Cherwell
DISTRICT COUNCIL
NORTH OXFORDSHIRE

TOWN AND COUNTRY PLANNING ACT 1990

Application No.:	22/03763/SCOP
Applicant's Name:	Oxford University Development Ltd
Proposal:	Scoping Opinion with respect to the scope and methodology of the Environmental Impact Assessment (EIA) in relation to re-development proposals of approximately 170 hectares (Ha) land at the existing Begbroke Science Park and surrounding land. The findings of the EIA will be reported in an Environmental Statement (ES) which will accompany the planning application
Location:	Begbroke Science Park Begbroke Hill Begbroke Kidlington OX5 1PF
Parish(es):	Begbroke, Kidlington and Yarnton

Figure 2.2: Transport Constraints⁴

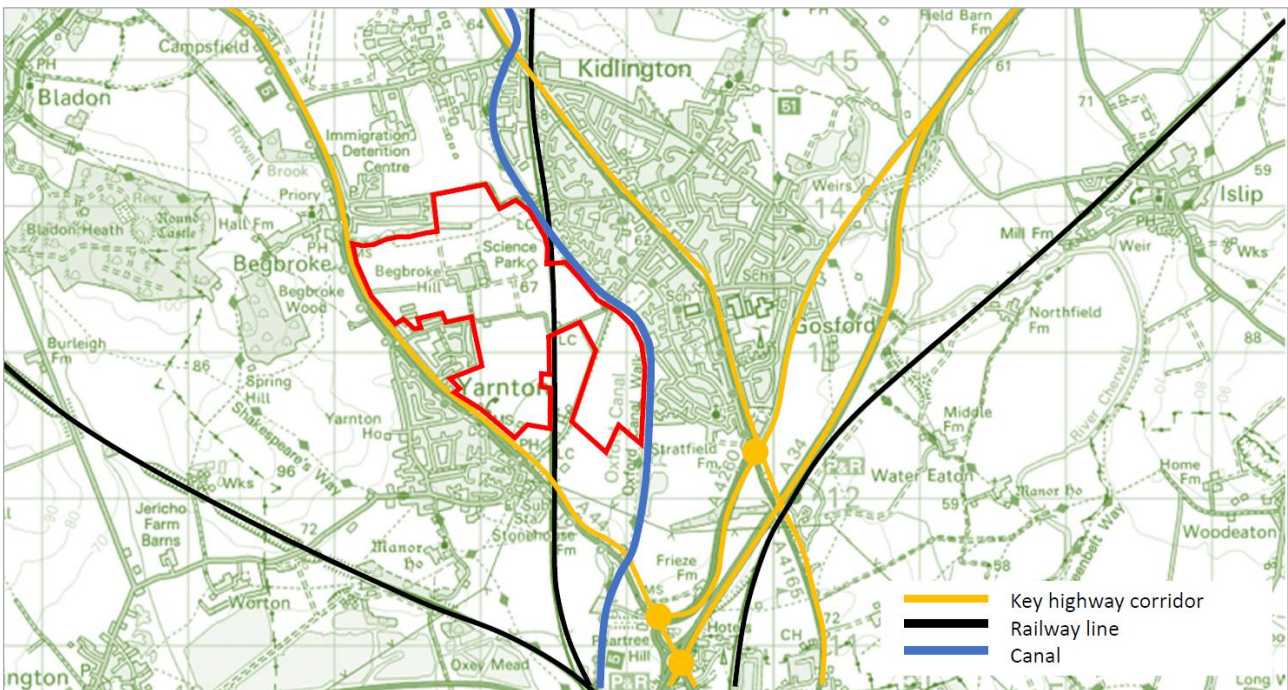
Paragraph 7.3 states the route is currently closed to vehicles and only open to pedestrians and cyclists however it is understood that the route is currently open

Paragraph 7.37 refers to Yarnton LC being currently closed to vehicles however the Level Crossing is still open and used by vehicles – the cottage uses still uses the crossing. Yarnton LC closure should be considered in all scenarios.

Figure 8.1: Baseline Noise Contour map

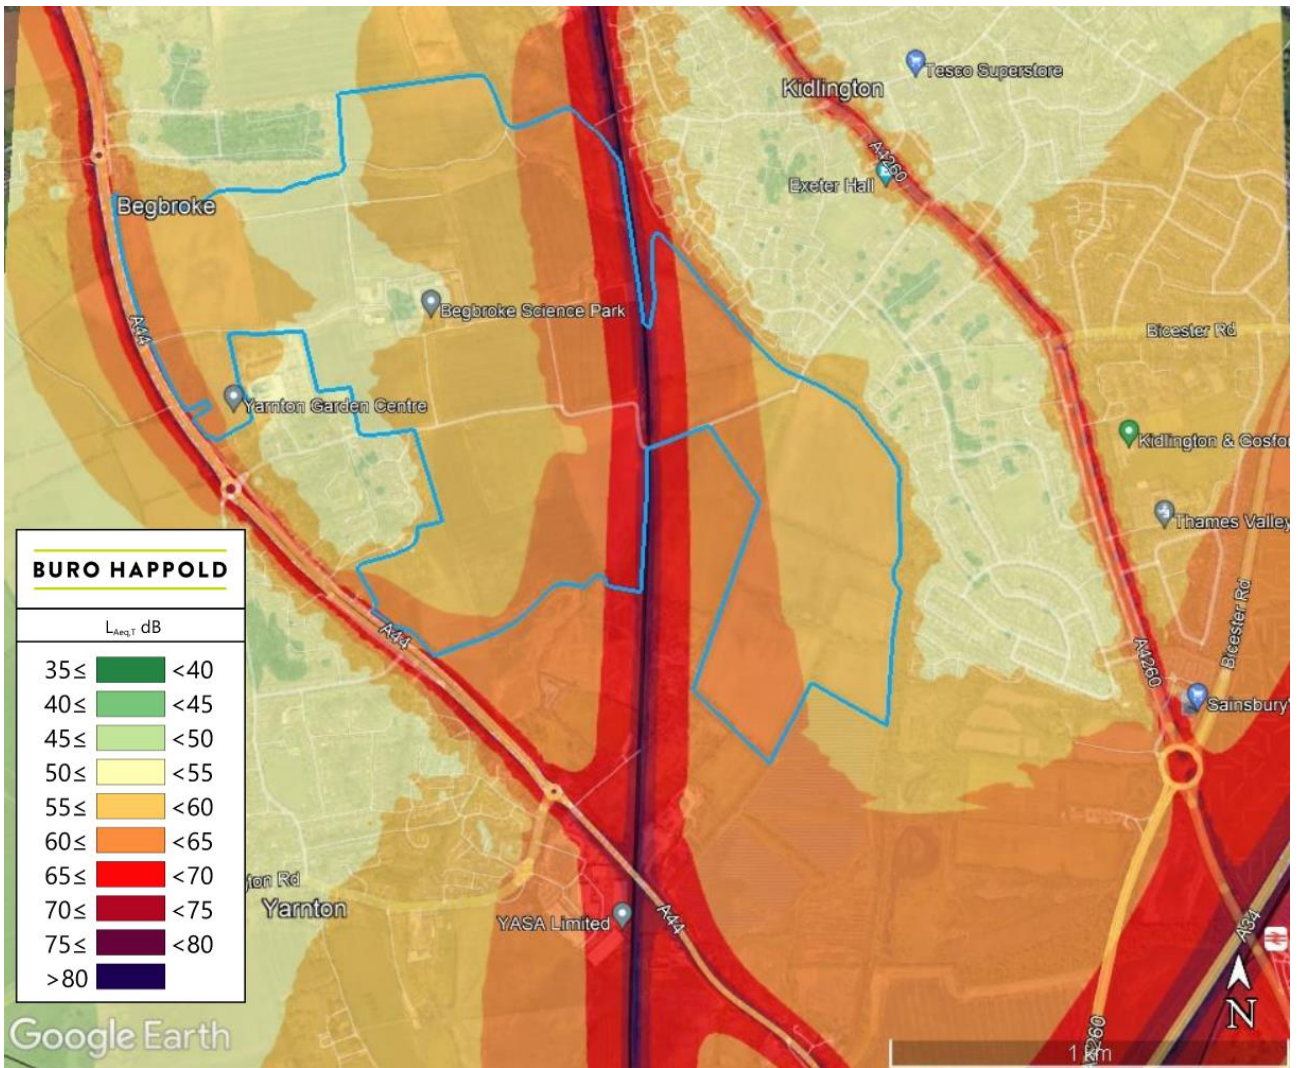
The noise contour map of the existing baseline shows noise levels to the western boundary and land adjacent to the railway line to be above the permitted level of 50dB LAeq, 30min at the boundary for school sites. The existing number of rail movements of 15 trains per hour, equivalent to one every 4 minutes (item 8.2), and the anticipated increase in rail movements (item 8.8) will increase the noise levels. Noise will directly impact education delivery and is one of the reasons why a school must not be located adjacent to the railway line. The school location must meet the specified permitted noise level stated above unless otherwise agreed.
